EPC STORMWATER REVIEW COMMENTS IN ORANGE BOXES WITH BLACK TEXT

COLA, LLC. TRAILS AT ASPEN RIDGE FILING #4 FINAL DRAINAGE REPORT OVERVIEW MAP

DR-05

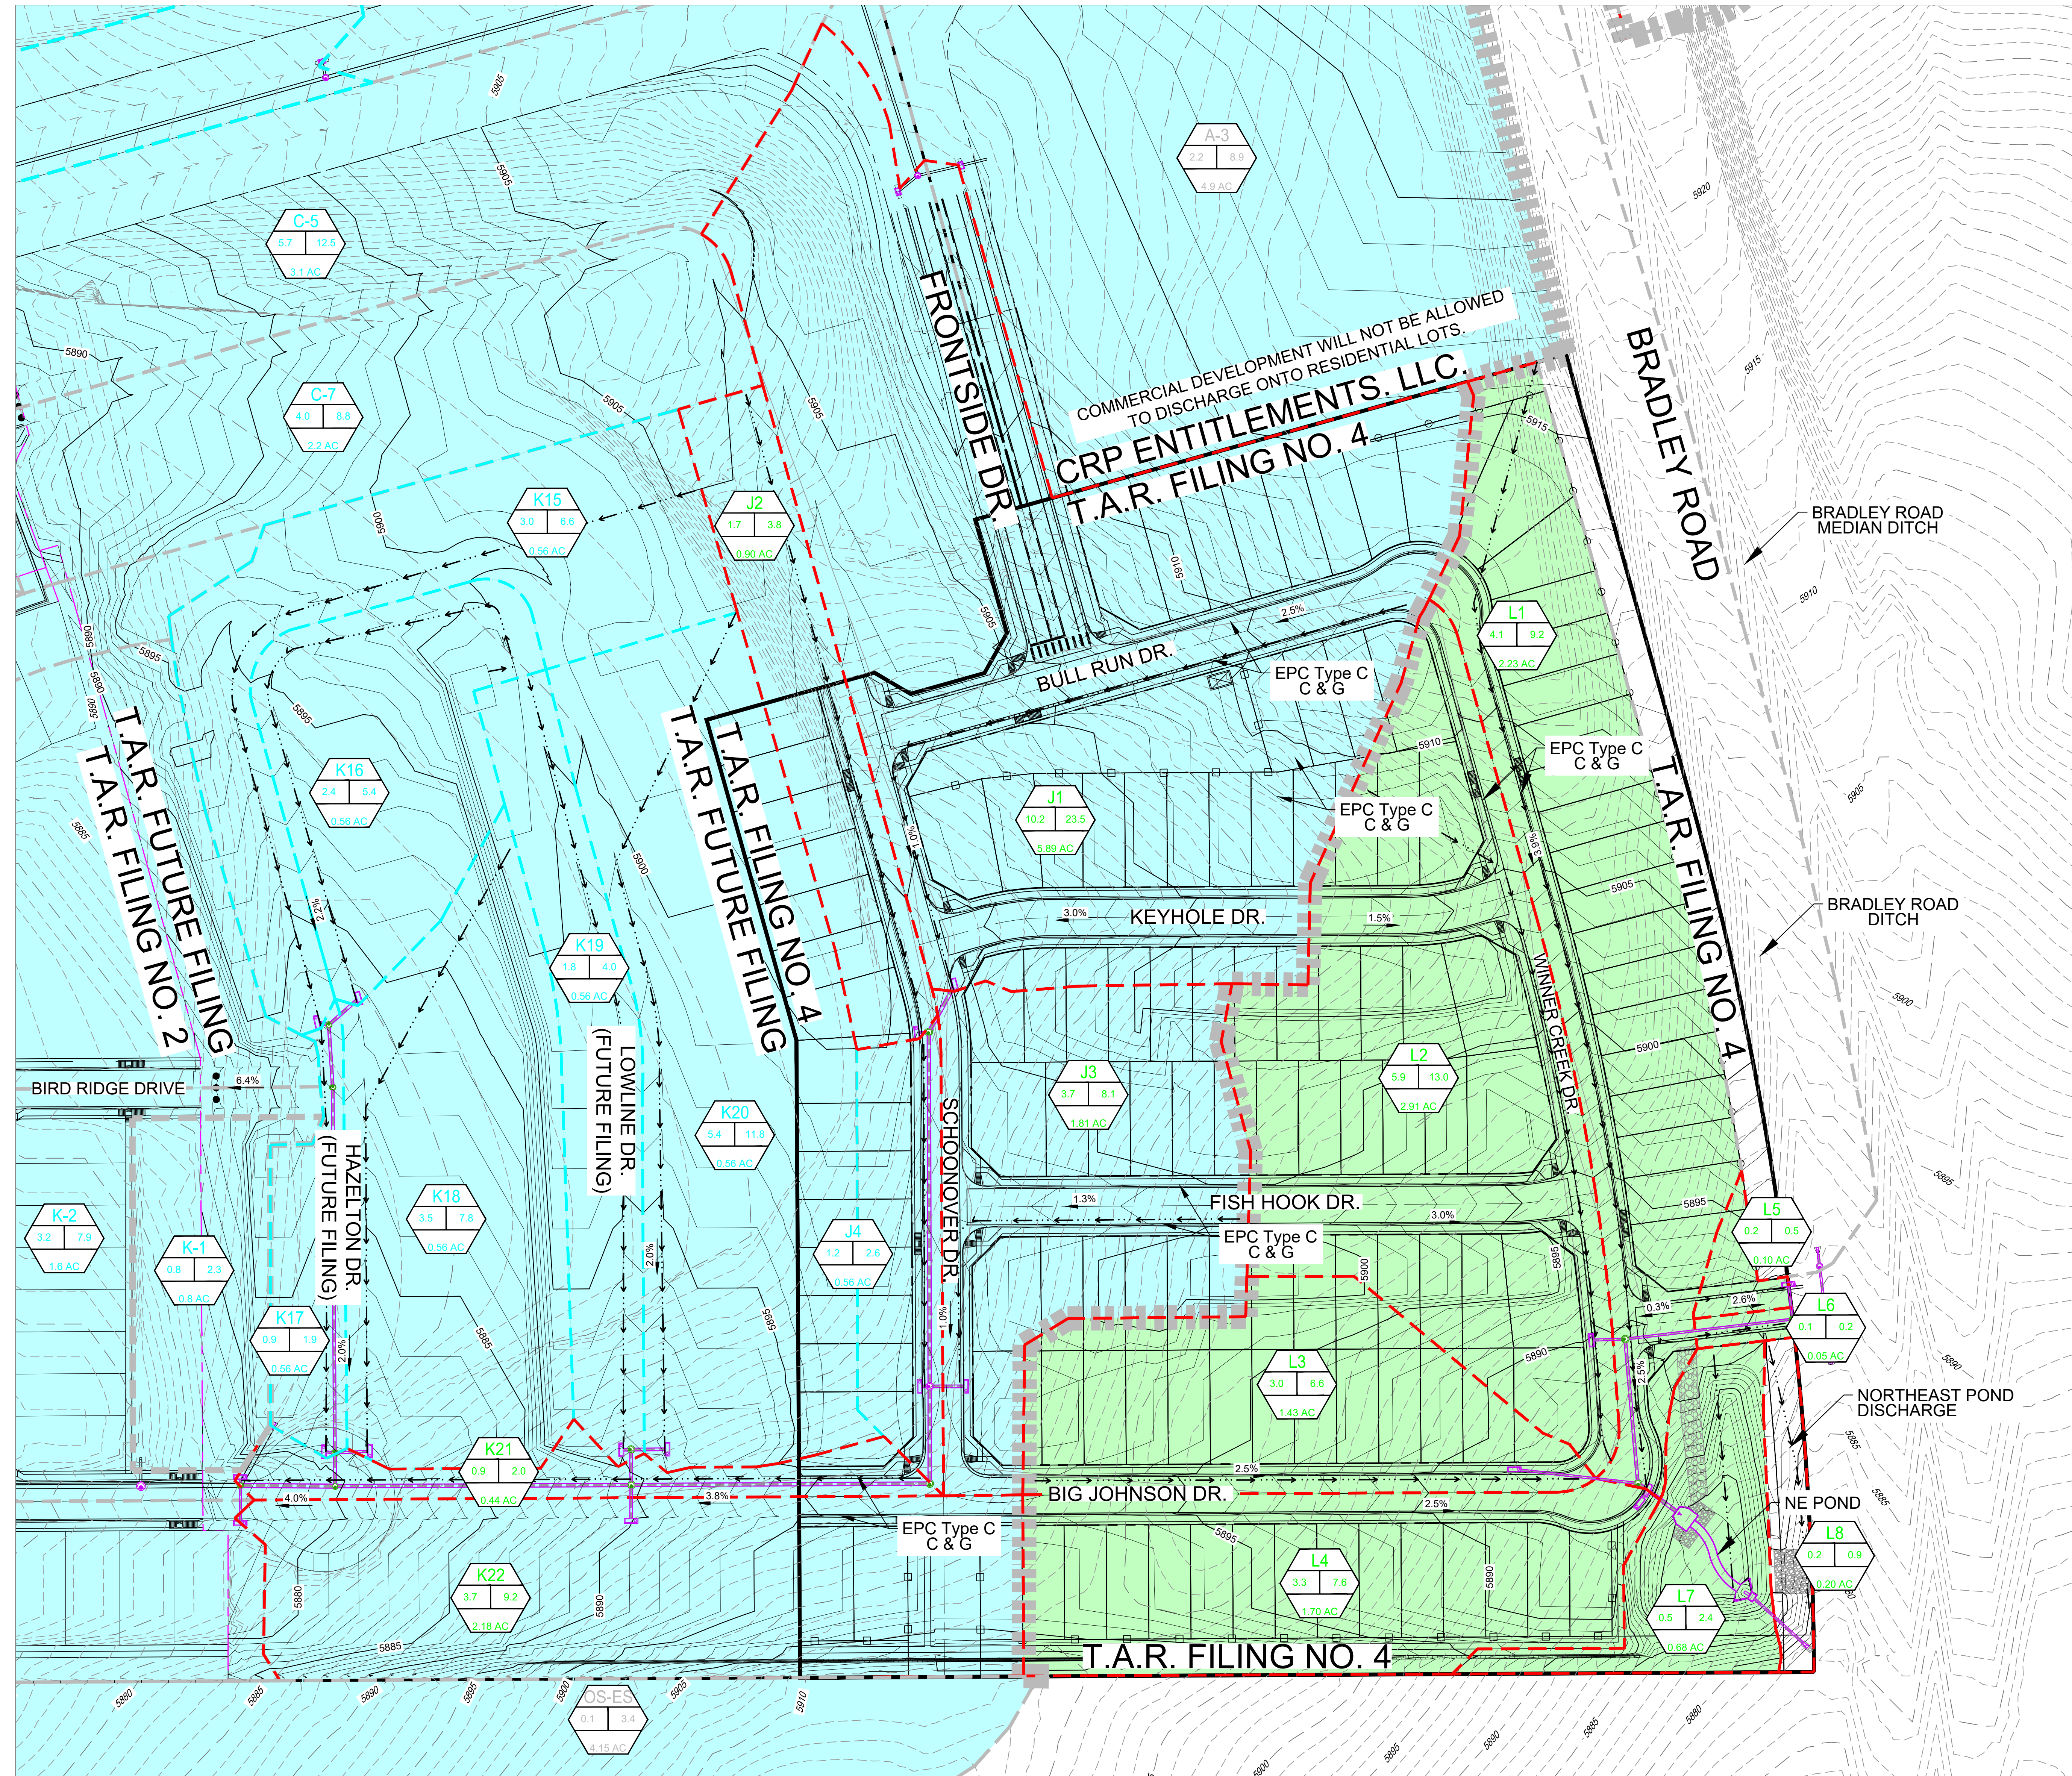
Please address all non-shaded areas in F4 with WQ treatment method or an applicable WQ exclusion. Im happy to get on a call to discuss best options.

Im not understanding how this is considered the 'NE Pond Discharge'. The pond outlet pipe is further downstream/east.
